From: Contact Centre (CRM) <contact@ribblevalley.gov.uk>
Sent: 03 June 2022 13:20
To: Planning
Subject: Planning Application Comments - 3/2022/0449

Planning Application Reference No.: 3/2022/0449

Address of Development: Lower Abbott House
Abbott Brow
Osbaldeston

site plan and roof plan

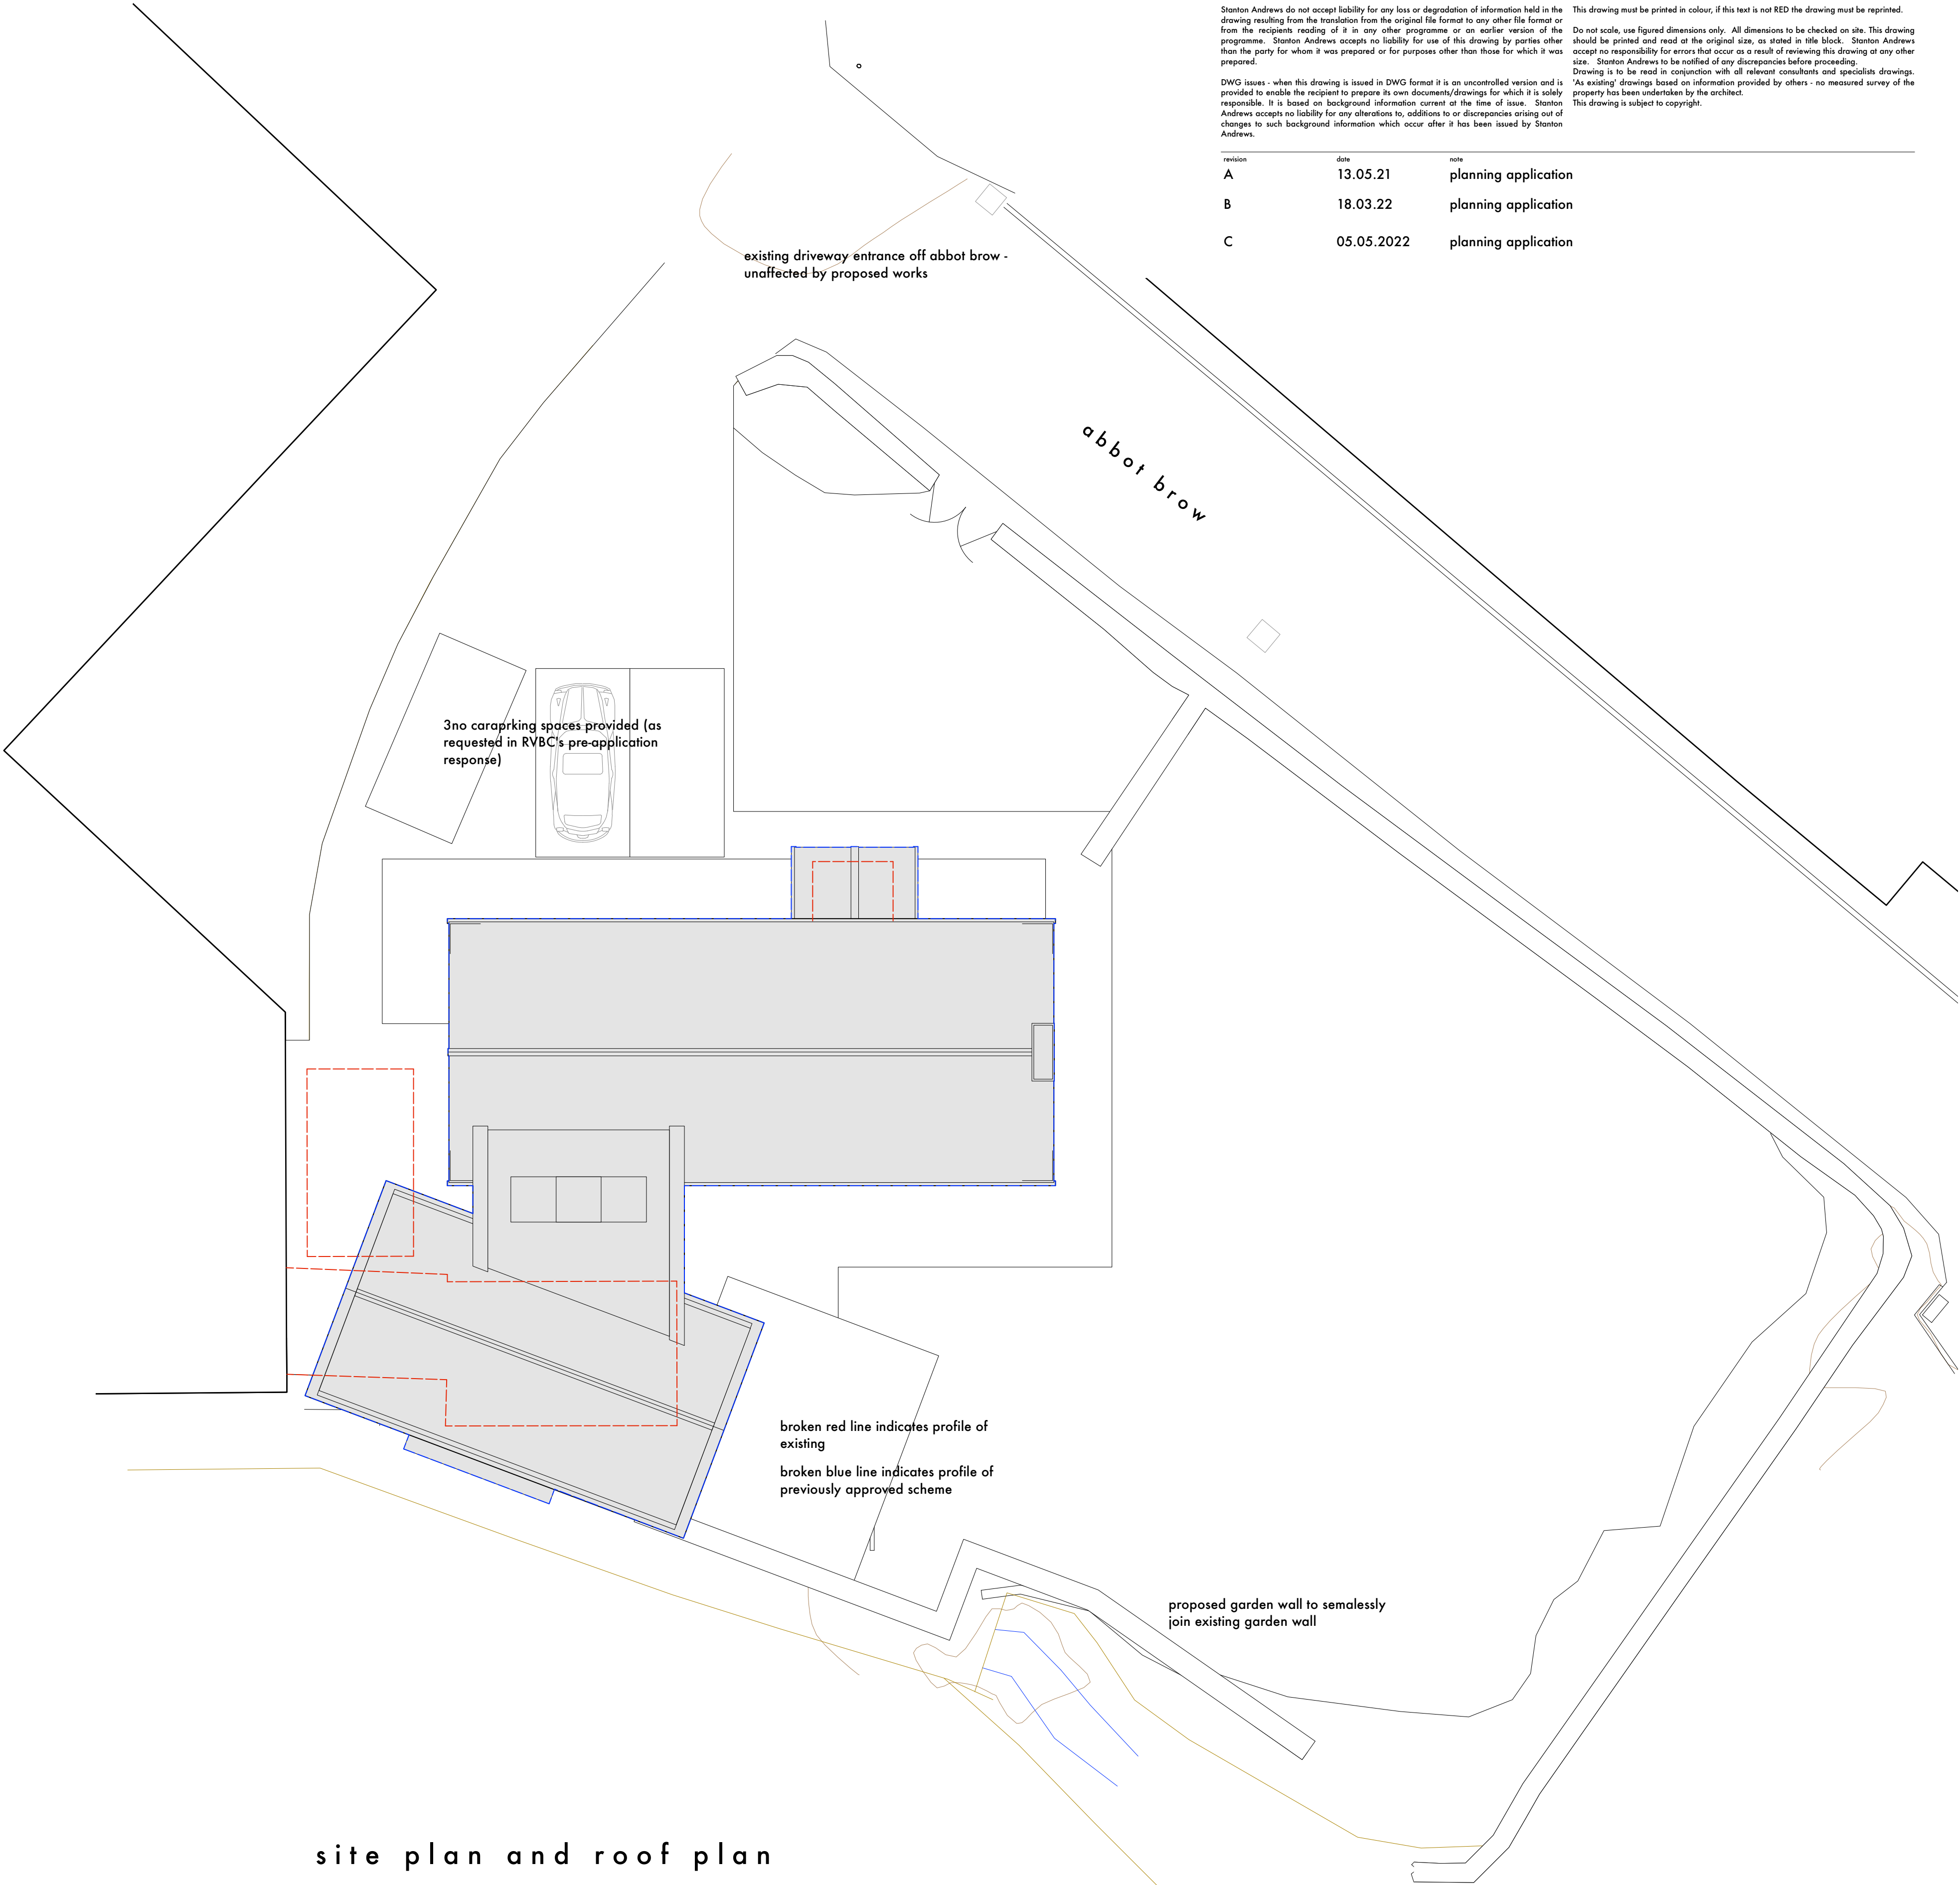
4 The agents have answered a question in relation to a water course on the site incorrectly . They have noted there is no water course within 20 m of the development . There is a culverted stream running not only under the site but also under the foundations of the new extension . This watercourse runs from Abbott Brow ,around the southern end of the site ,

through the site and exits in the NW corner of the site running through the adjacent field and then under the A59 . It can be clearly seen from the location plan and site survey .

The new extension is constructed on top of the culvert . If this culvert collapses or becomes blocked (which it is at present) it can cause the open stream to flood on the road [REDACTED]

We would suggest the position of the extension be reviewed given this information as it is our understanding that there is a specific formula for building adjacent to a culvert or watercourse which could ,dependant on the culvert size , restrict the construction of a building to as much as 6-10 m from the culvert . We also understand licences are needed for works adjacent to a stream and / or a culvert . There could also be a need to investigate if there are any affected species .
